Photographical study reviewing the Impact of the Planning Application Referenced EP/2/21/HH on neighbouring property of No.27

Objection From Mr Mrs C McNamara on Planning Application Ref: EP/2/21HH

Description of Works: Erection of front extension to create first floor balcony, following demolition of existing conservatory with changes to external materials and wall finishes.

Location: 27A Sea Lane, East Preston, BN16 1NH

Elevations (1:100)

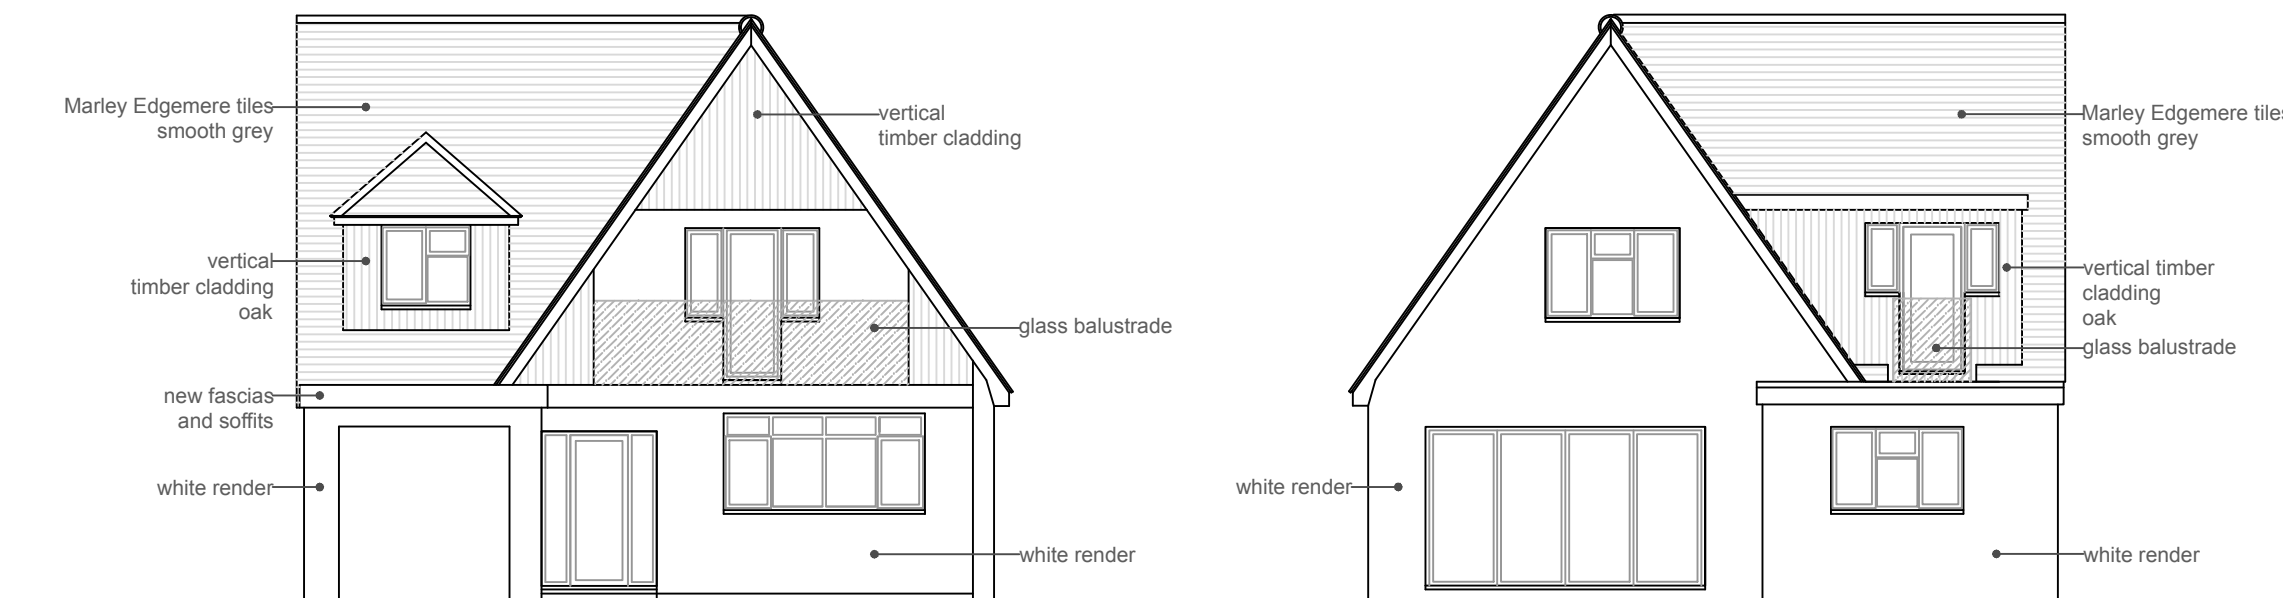
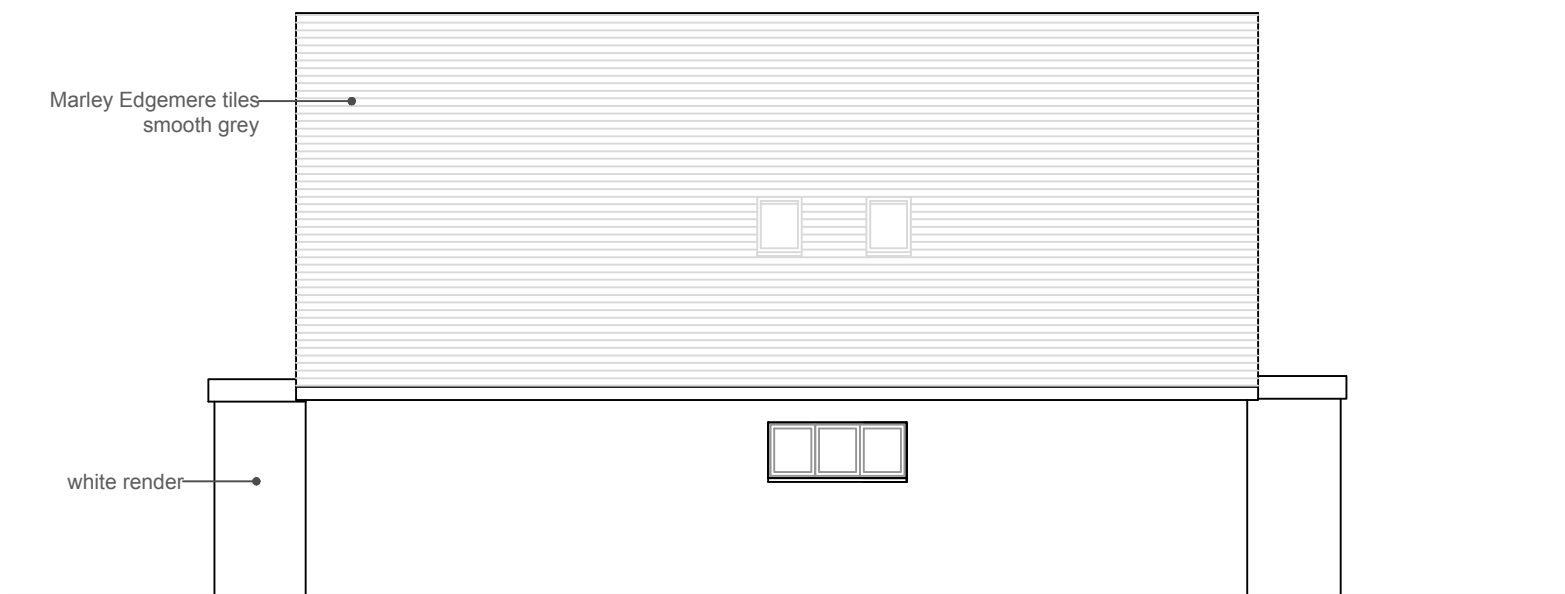
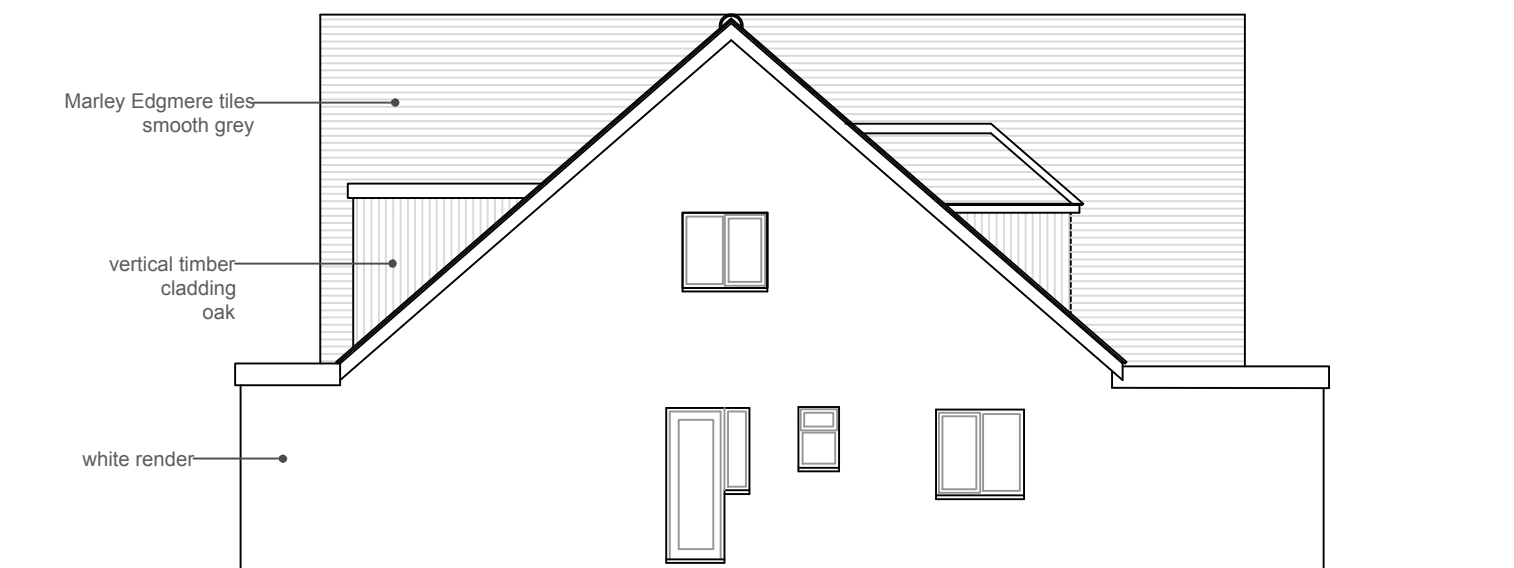
The dashed line indicates the proposed extended roof line with first floor front balcony - Extending this dominate roof form out would adversely block southern light onto our patio area.
